From: Shear Architectural Design LTD <[REDACTED]>
Sent: 19 February 2020 16:28
To: Sian Eggington
Subject: Re: FW: Further Information Required on Your Ref: PP-08514407 Our Ref: EP/21/20/HH
Attachments: We sent you safe versions of your files; 123 Roundstone Drive Littlehaption PRELIM rev E.pdf
Categories: Green Category

Proposed Front Elevation
Scale: 1:100

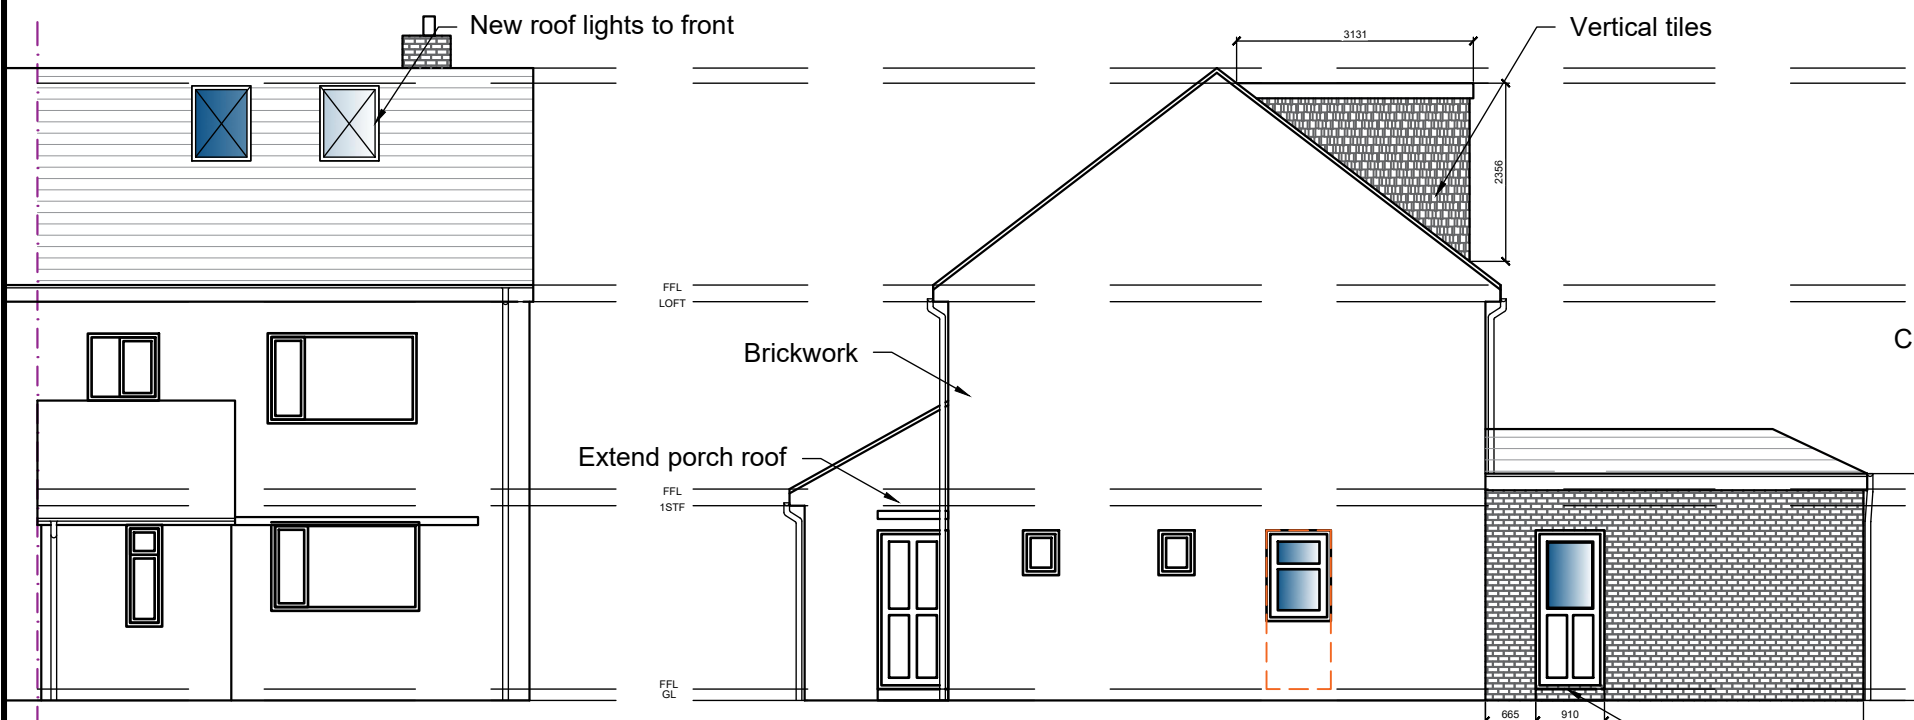
Apologies the invalid letter doesn't seem to have generated point 2 in our system. We require a proposed front elevation as you are proposing changes to the elevation with the addition of the 2x rooflights. As this was a system error I'm happy to backdate the application to today (when we received the earlier additional information). Please submit at your earlier convenience.

No worries, I have attached the revised DWGs to show a front elevation.
